CHALLENGER HOMES	8605 EXPLORER DRIVE SUITE 250 COLORADO SPRINGS, CO 80920 719-598-5192 JIM BYERS
CHALLENGER HOMES	FALCON HIGHLANDS SOUTH EL PASO COUNTY, COLORADO CONSTRUCTION PLANS GRADING AND EROSION CONTROL PLAN INITIAL GEP
CLIENT	
DATE	4/18/2023
A 1st SUBMITTAL TO EPC	07/29/2022 - RDL
REVISIONS	
COUNTY FILE NO.:	PUDSP-22-005
DR.	JD
CH.	
P.M. RDL	
JOB	21005234
SHEET NO.	3

CHALLENGER HOMES
FALCON HIGHLANDS SOUTH
EL PASO COUNTY, COLORADO
CONSTRUCTION PLANS
GRADING AND EROSION CONTROL PLAN
INITIAL GEP

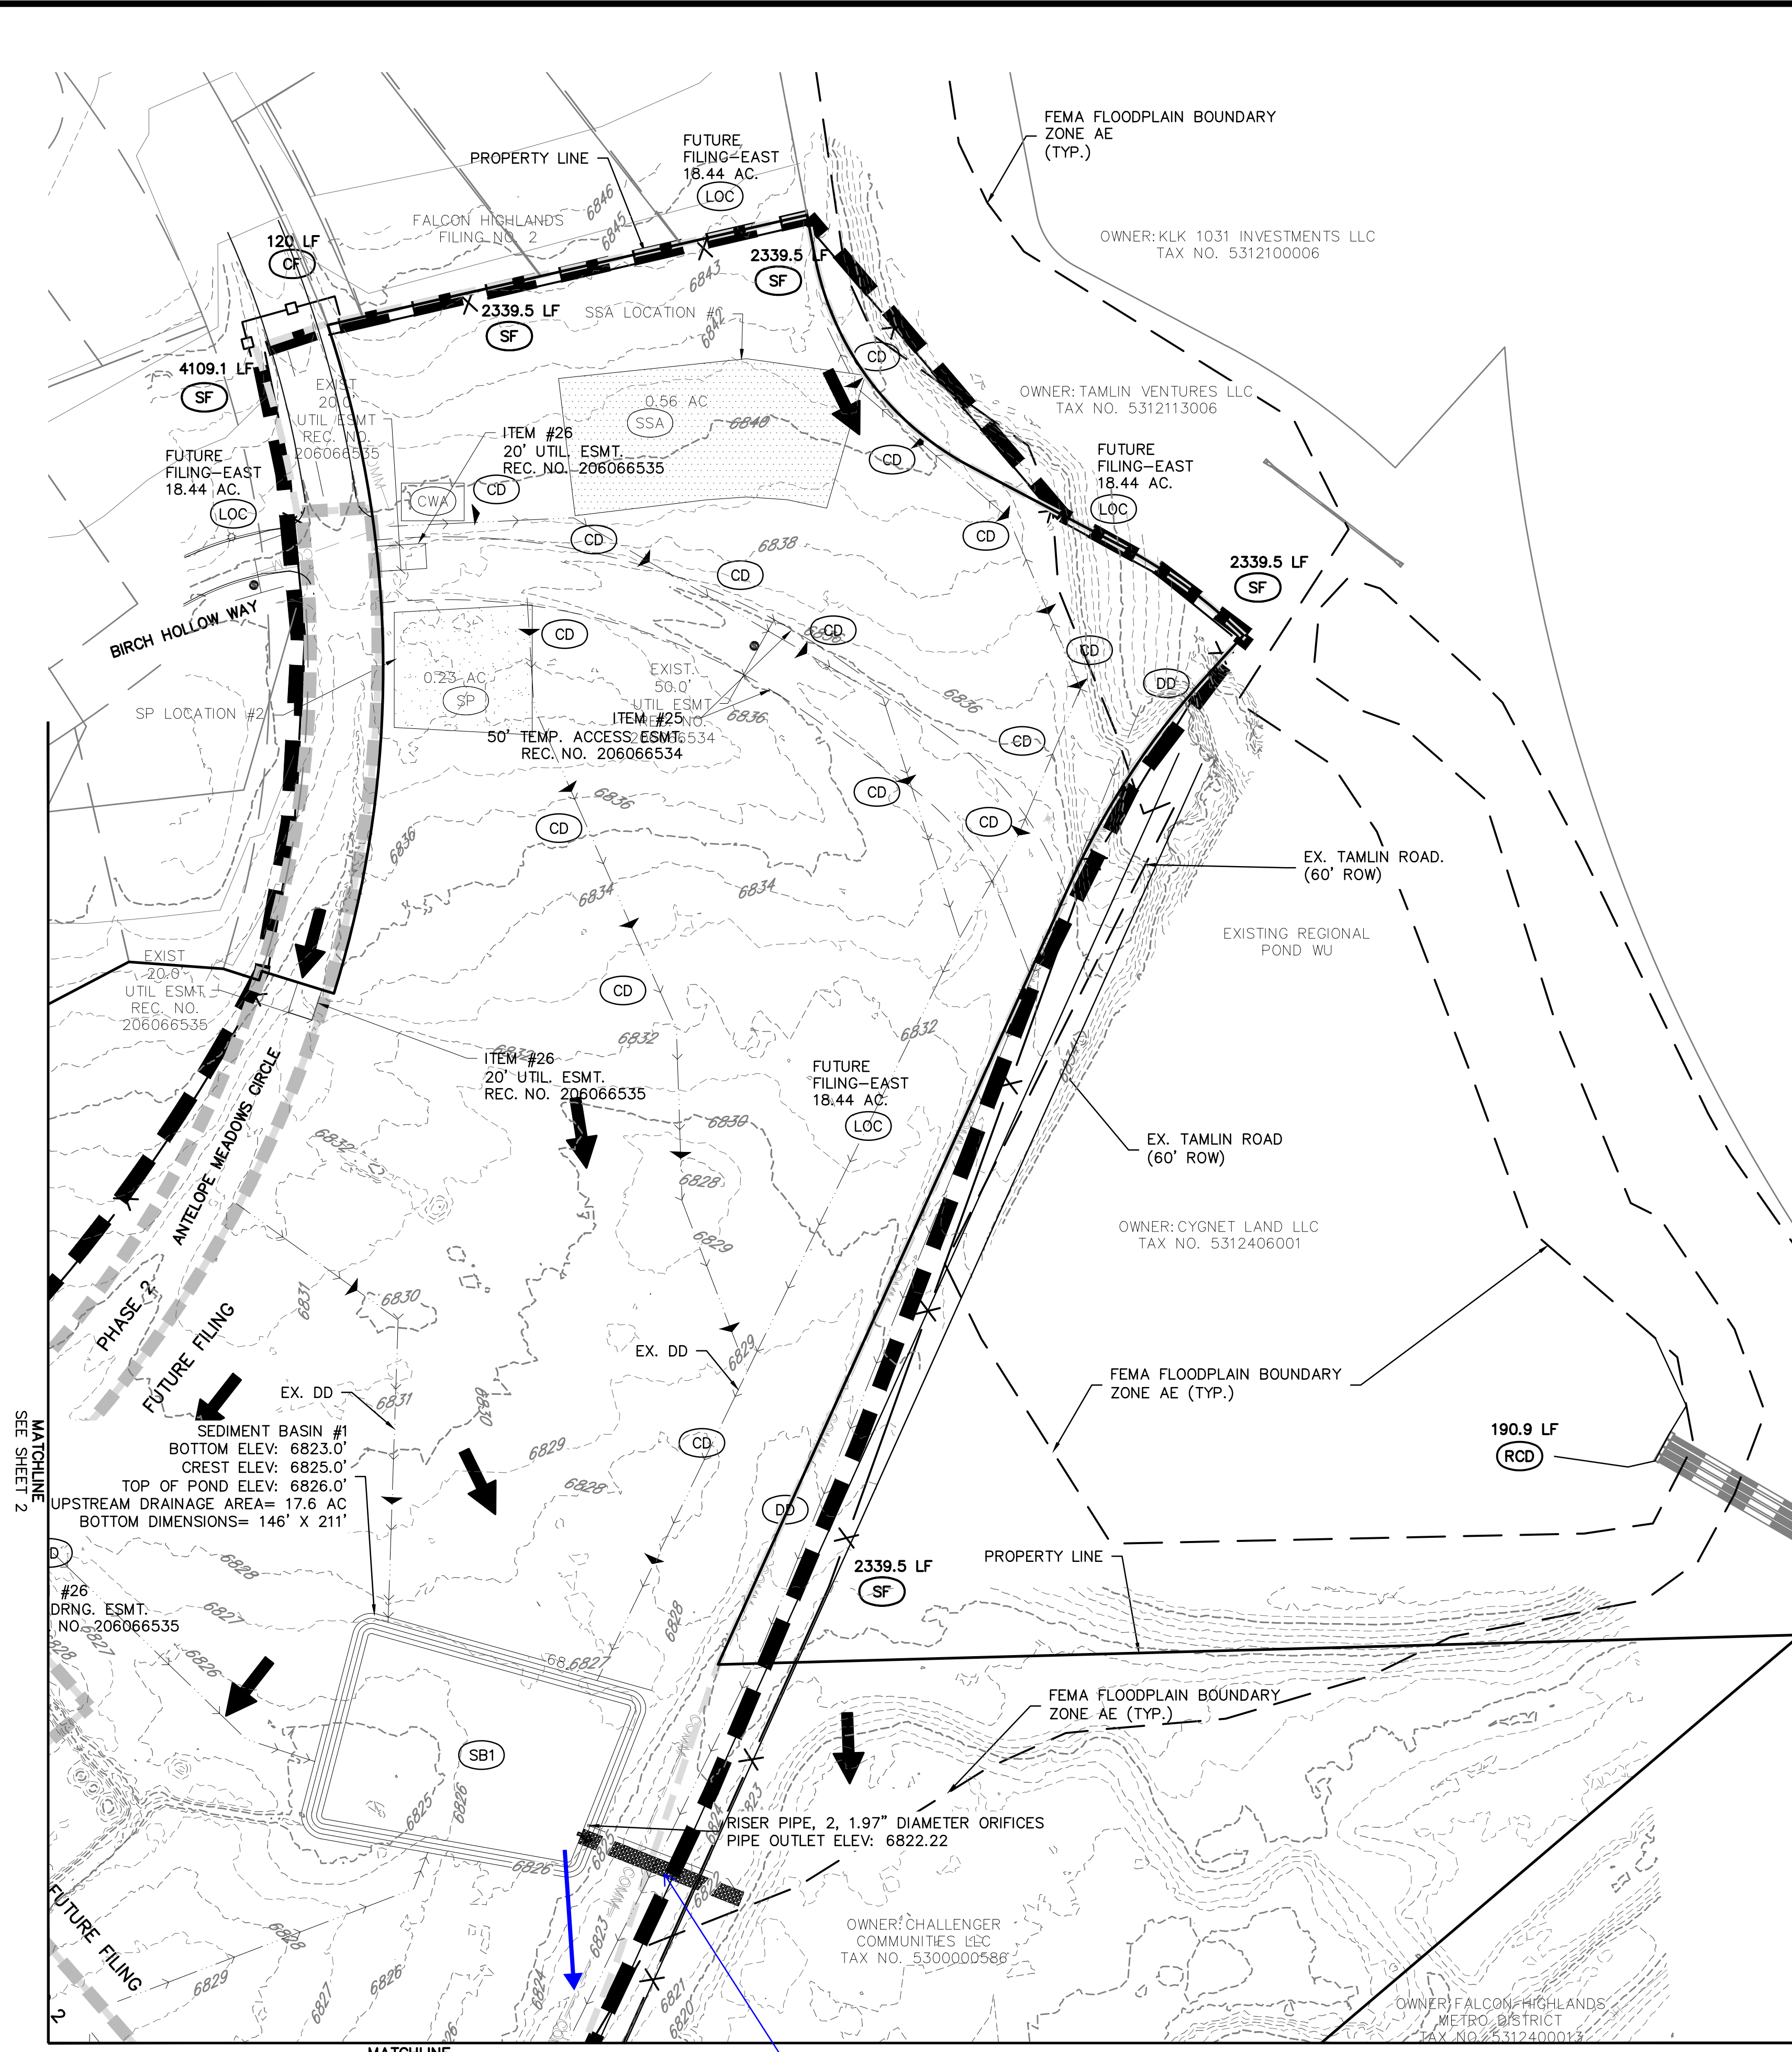
Add hatching to legend.
Spillway can't be over road and trail area. Provide a culvert or different outfall - existing roadside ditch?

the drain pipe and spillway have been directed towards the existing borrow ditch on the north/west side of the Tamlin Road right-of-way
